We would not recommend approval until the following points have been addressed;

### **Condition 13**

### **Condition 15 - Maintenance**

TITLE: Proposed Drainage and Levels Layout Plan
Phase 1 - Whole Site

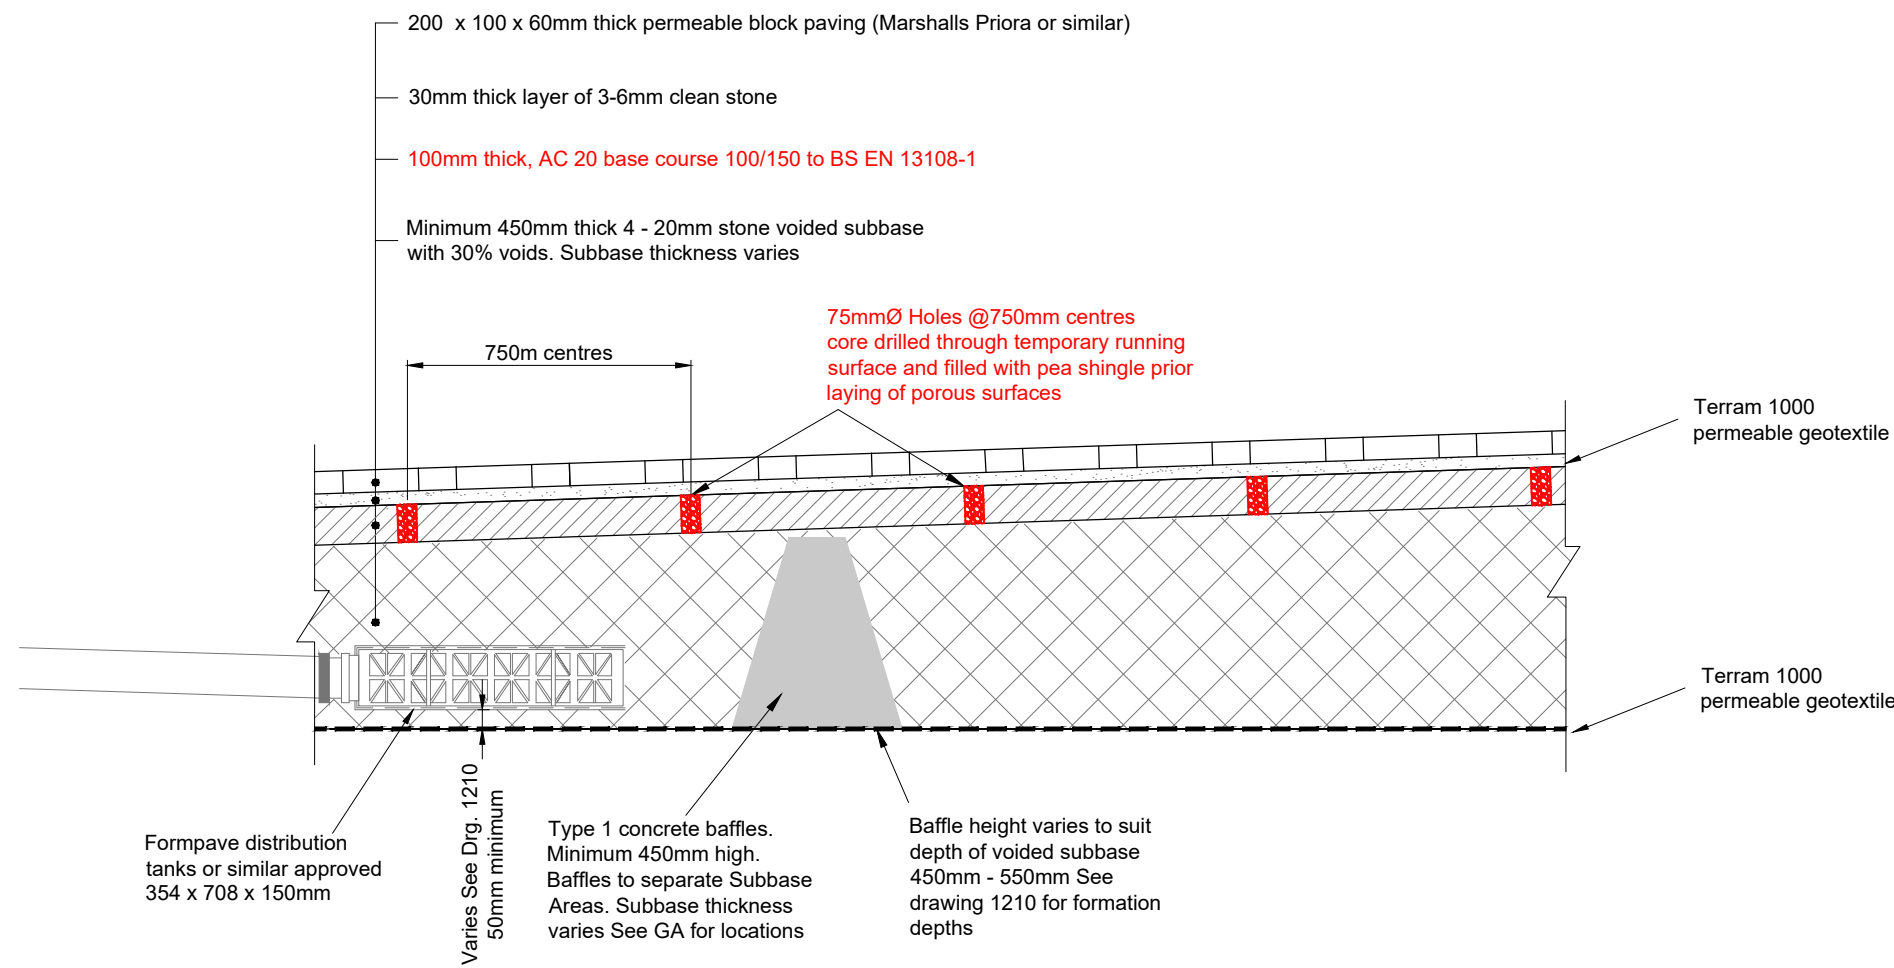
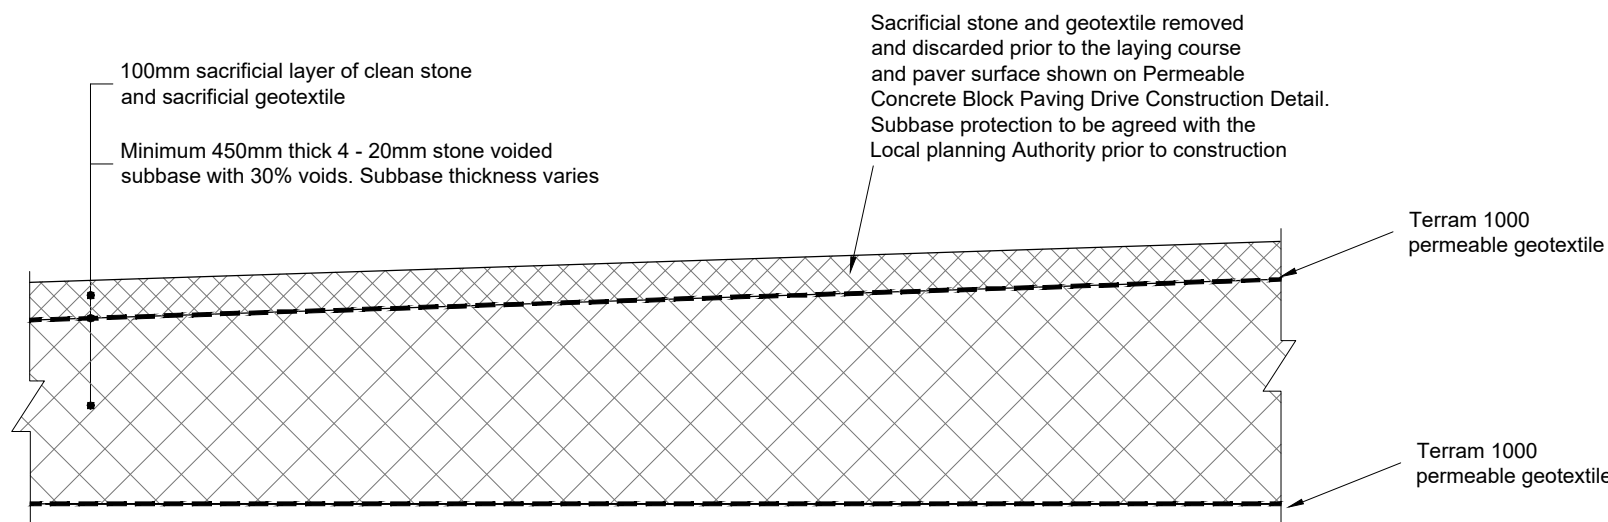
2. The verification report notes several inaccuracies with the as-built drawings. The as-built drawings should be updated to reflect what has actually been constructed.

No verification has been provided, the applicant has cited our (Arun DC) guidance for post construction verification being acceptable. Please may we have a copy of this email, including the attachments, as we believe this may be a misunderstanding of our questions, or the guidance.

PERMEABLE CONCRETE BLOCK PAVING CARRIAGEWAY & DRIVE CONSTRUCTION DETAIL
Scale 1:20

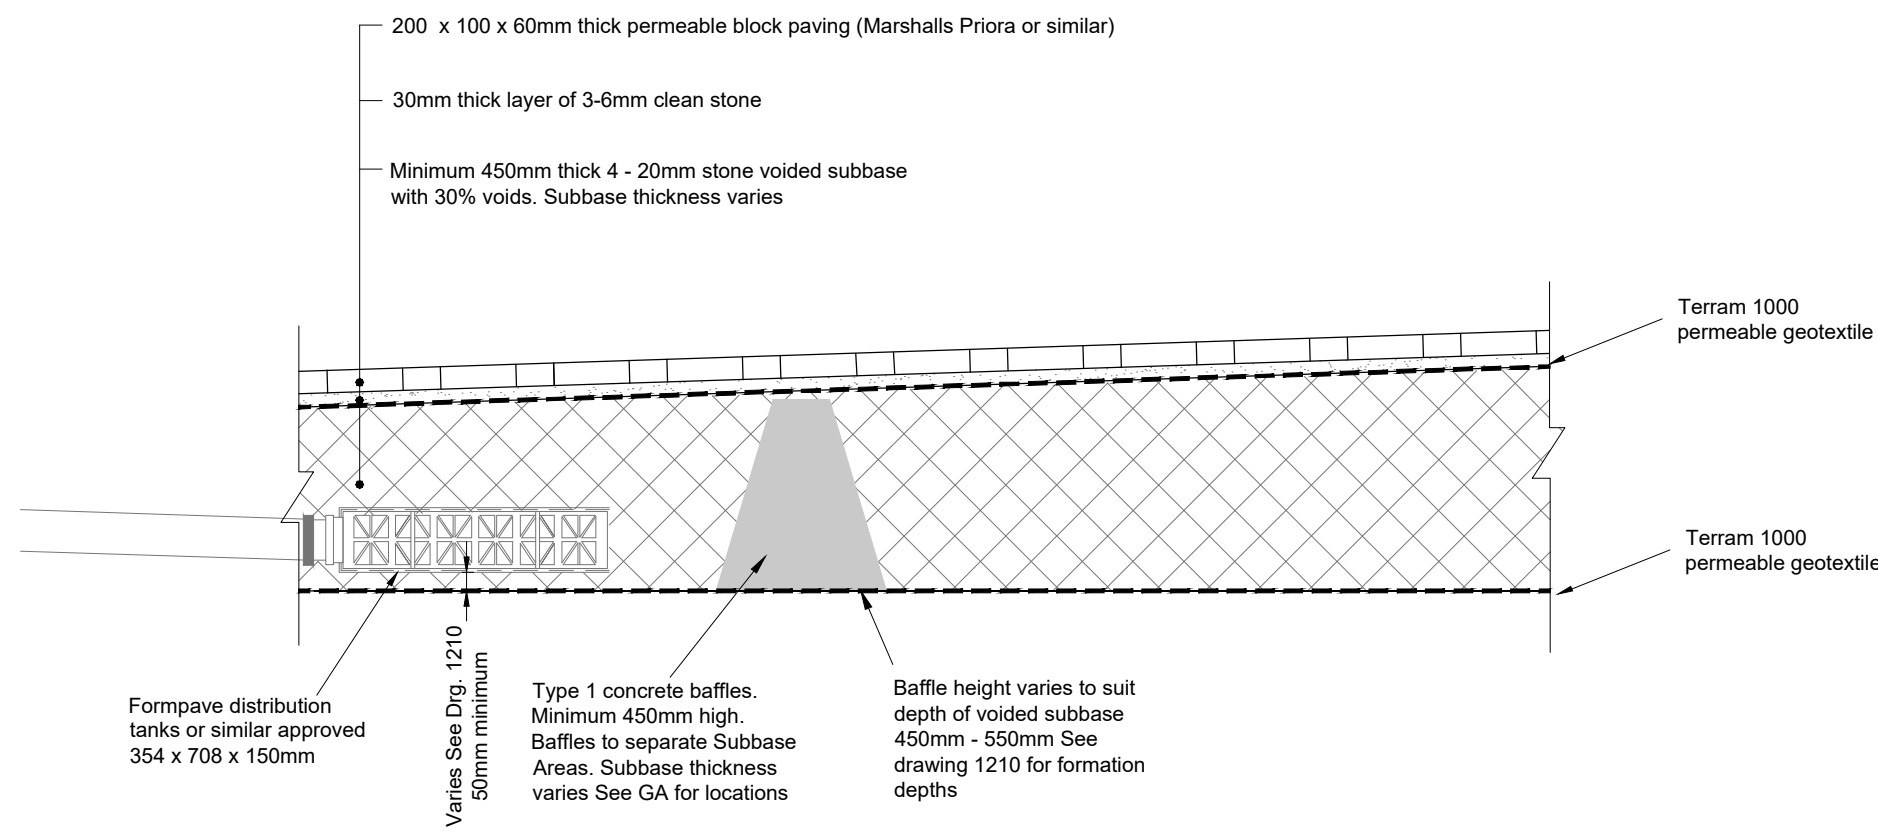
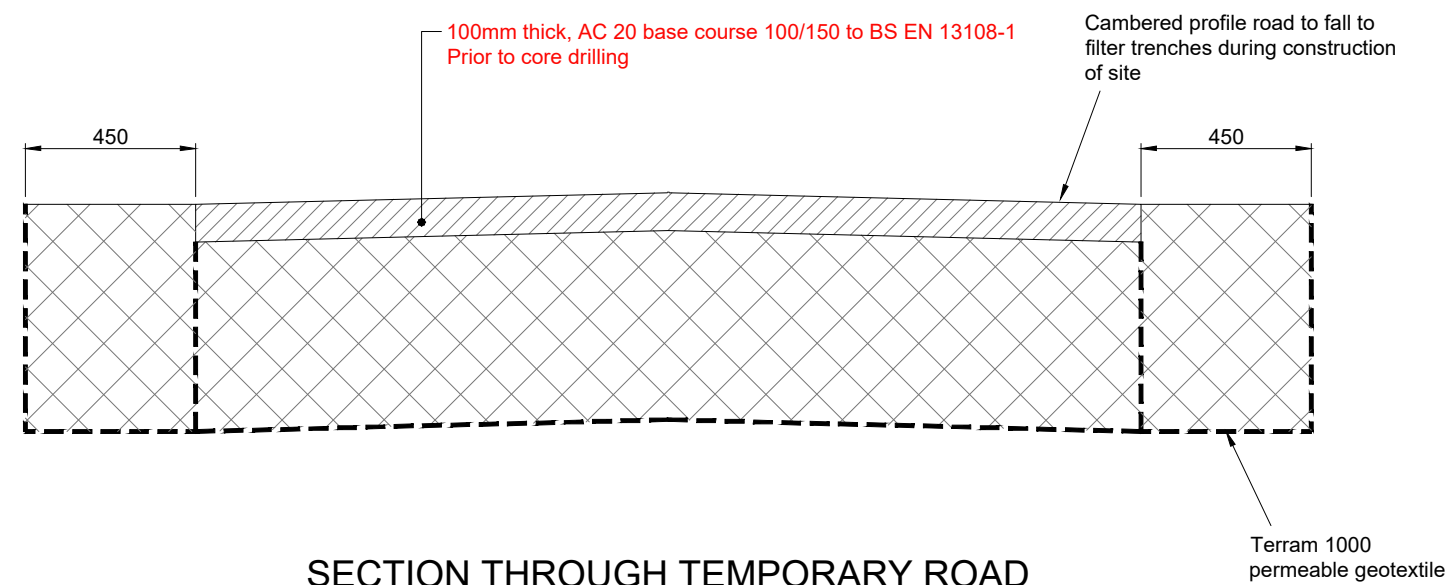
1. The applicant has stated "A 30% void ratio has been assumed for the volumes used for storage" and "Details for construction of these beddings has not been provided within the construction details in the technical note provided, nor could it be verified during the site visit."

We request evidence be provided to demonstrate that a suitable low fines 30% (or greater void ratio) aggregate has been used. This evidence can be provided in the form of receipts, further surveys, or any other method for confirming the product used for the sub-base was of a suitable quality.

This point has been addressed by applicant and confirmation that 30% porous sub-base used provided.

The evidence is included in the email from the 5<sup>th</sup> of October 2022, which includes attachments. Having checked this we can confirm receipts for low fines gravel have been provided.

CATCHPIT CHAMBER
(Scale 1:20)

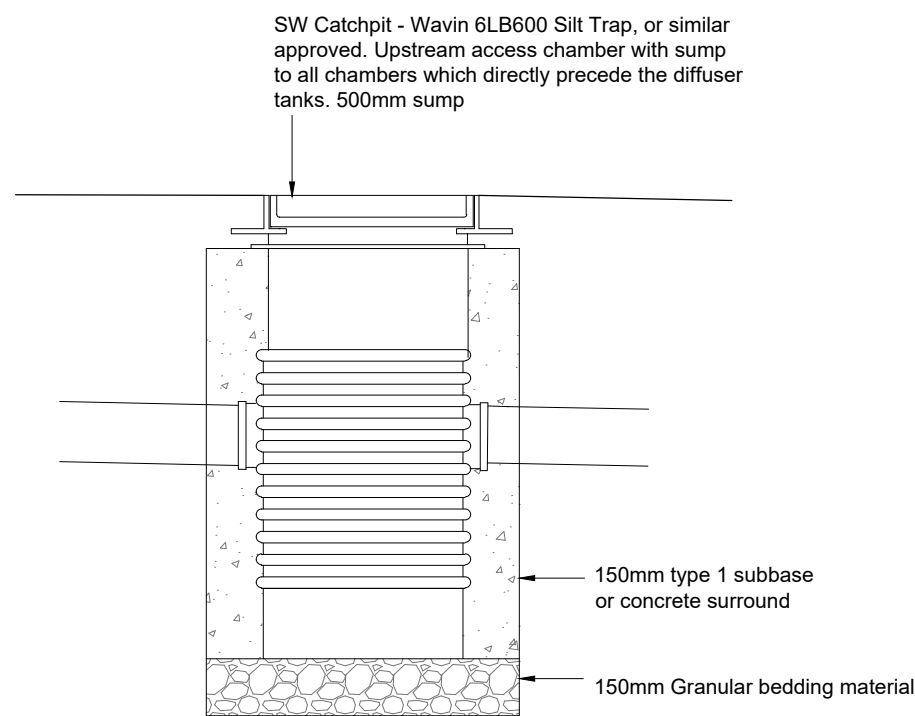
4. The bedding material and granular surround on some of the catch pits could not be confirmed and is stated as 'unknown' in the verification report. In addition, the photographs do not clearly show the quality of the installation of the inlet and outlet pipes in each catchpit, meaning it is not possible to confirm whether they are adequately sealed. Further clarification on the construction of the catch pits should be provided once construction has been completed (this can be provided as part of the final survey, point 5 below).

The email from the 5<sup>th</sup> of October 2022 should have also included an attachment showing the concrete base. Having checked this email, the concrete base photograph does not appear to have been included.
